Extension and new roof to garage. This application lies within the South Downs National Park Authority.

Chevening's 36 High Street Findon

I regret that I am unable to accept your documents as a formal application until the following matters have been resolved :-

location
plan 1:1250

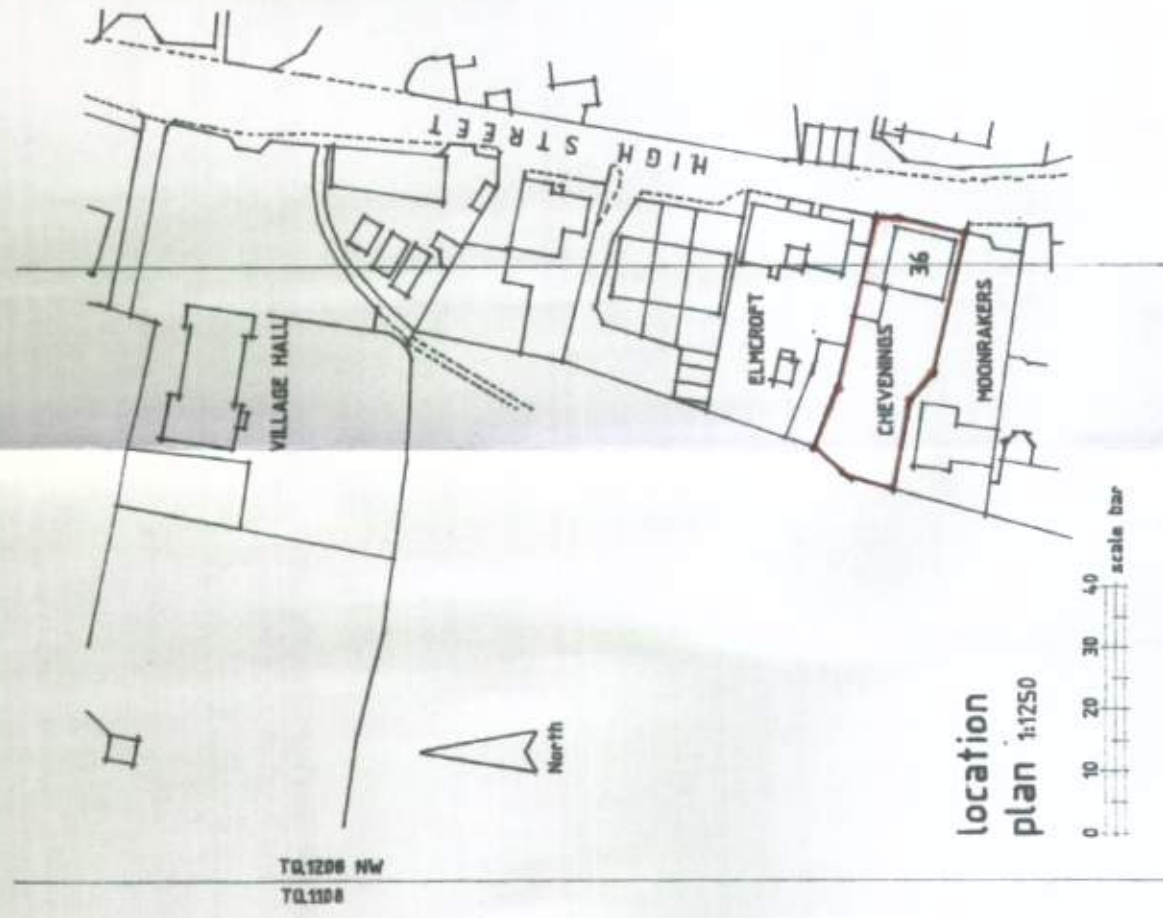
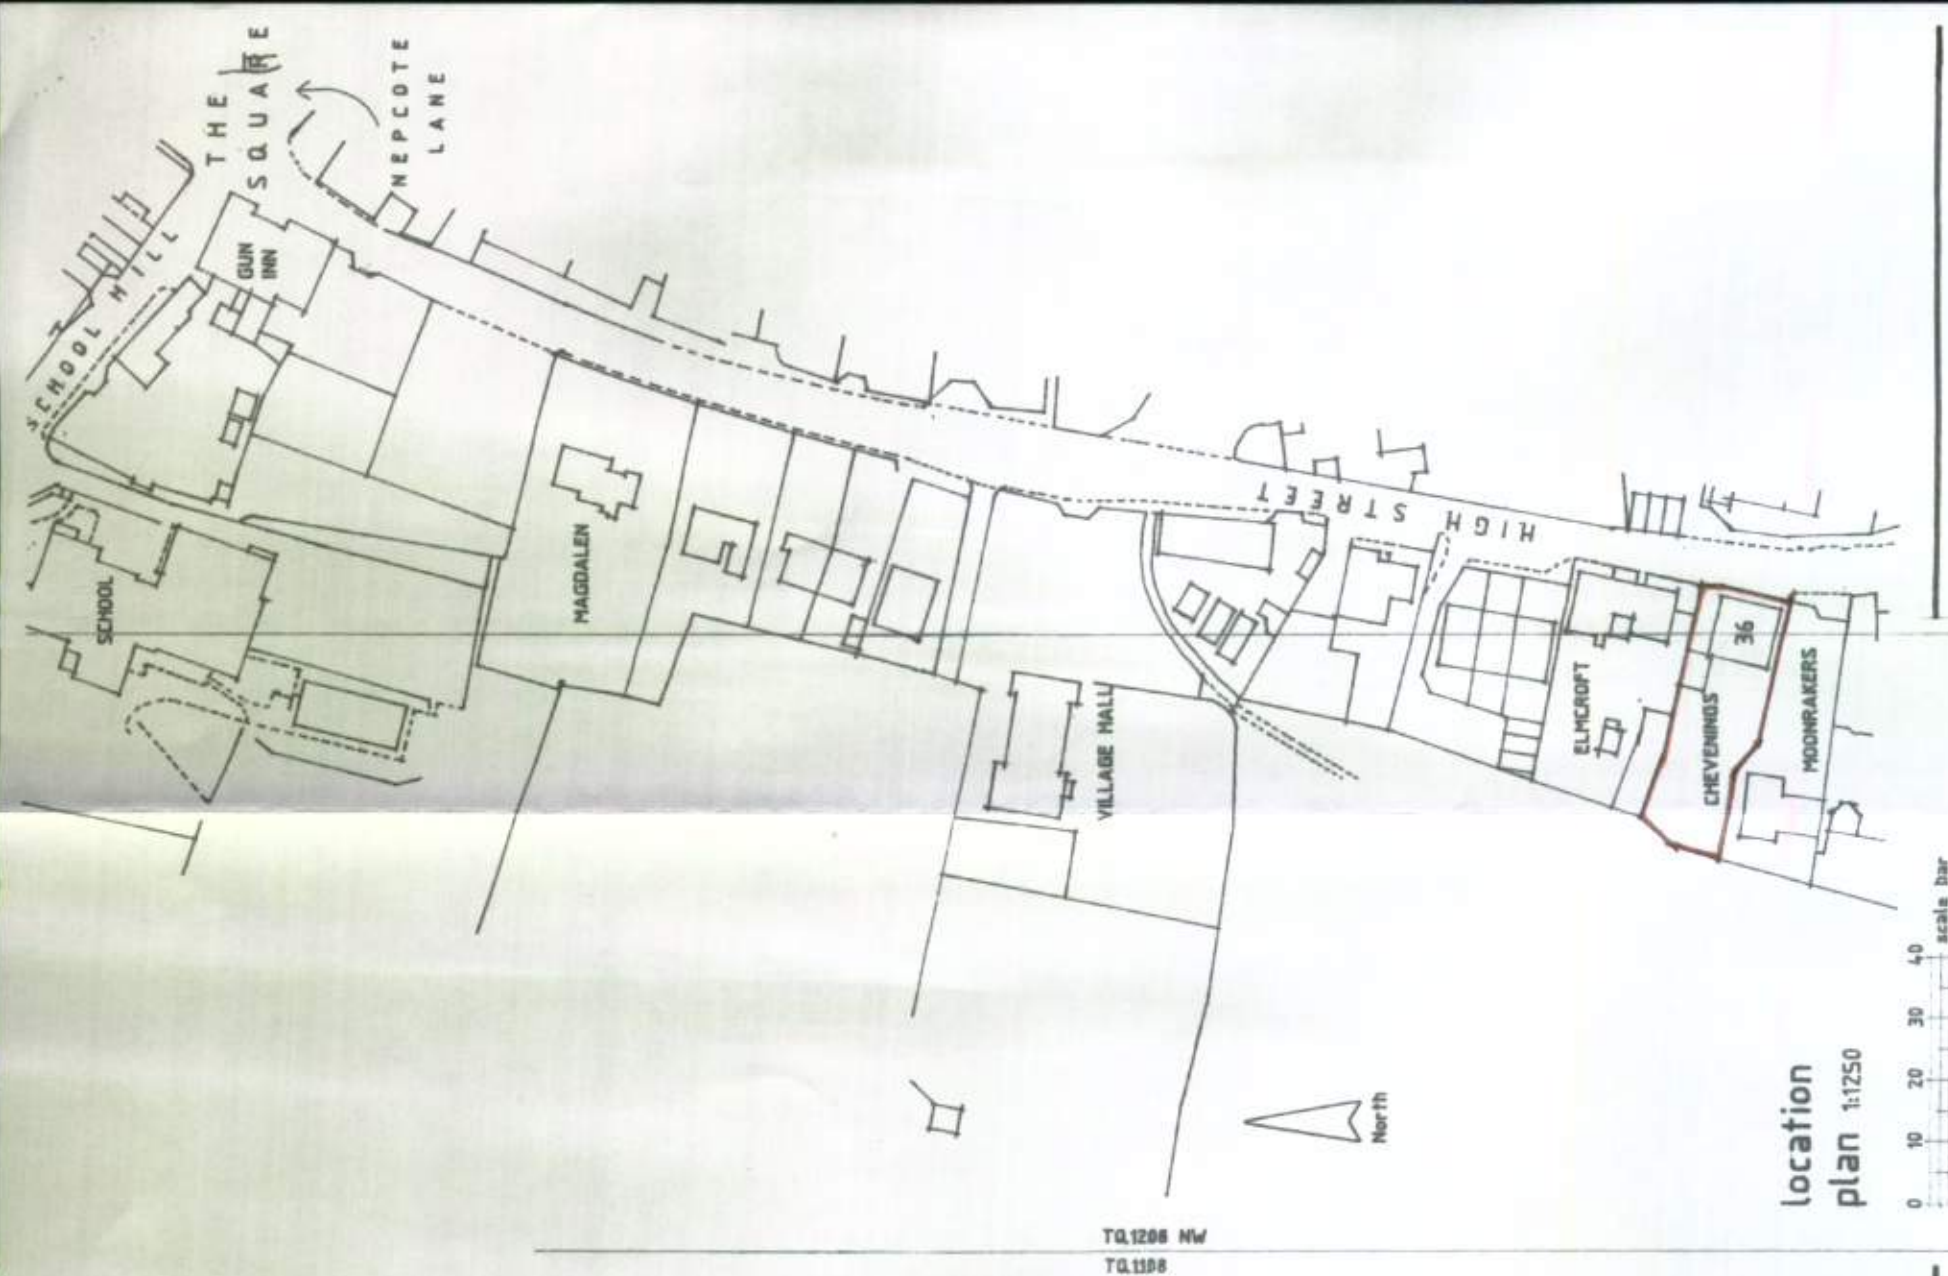
I require 1 electronic or 3 paper copies of a revised location plan to include another named road in accordance with the guidance notes available on our website detailed below (click on National List).

site plan 1:500

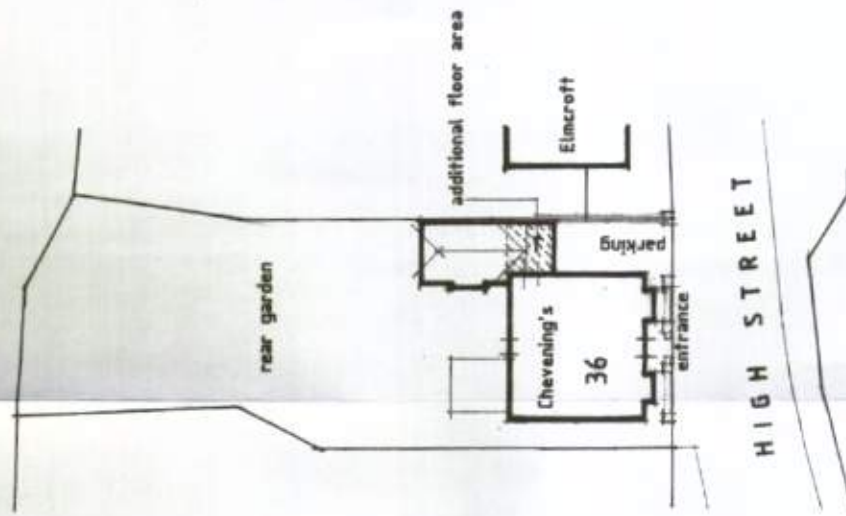
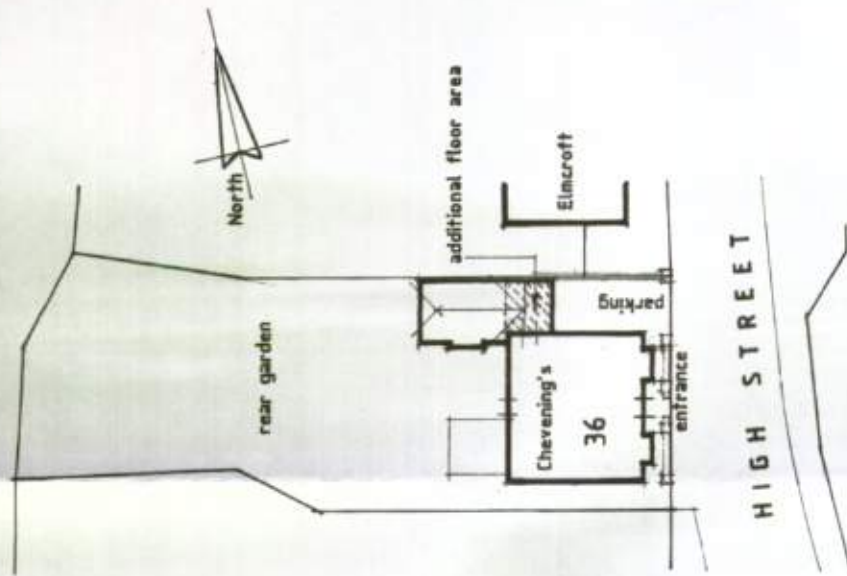
I require 1 electronic or 3 paper copies of a revised block/site plan to include a north point in accordance with the guidance notes available on our website detailed below (click on National List).
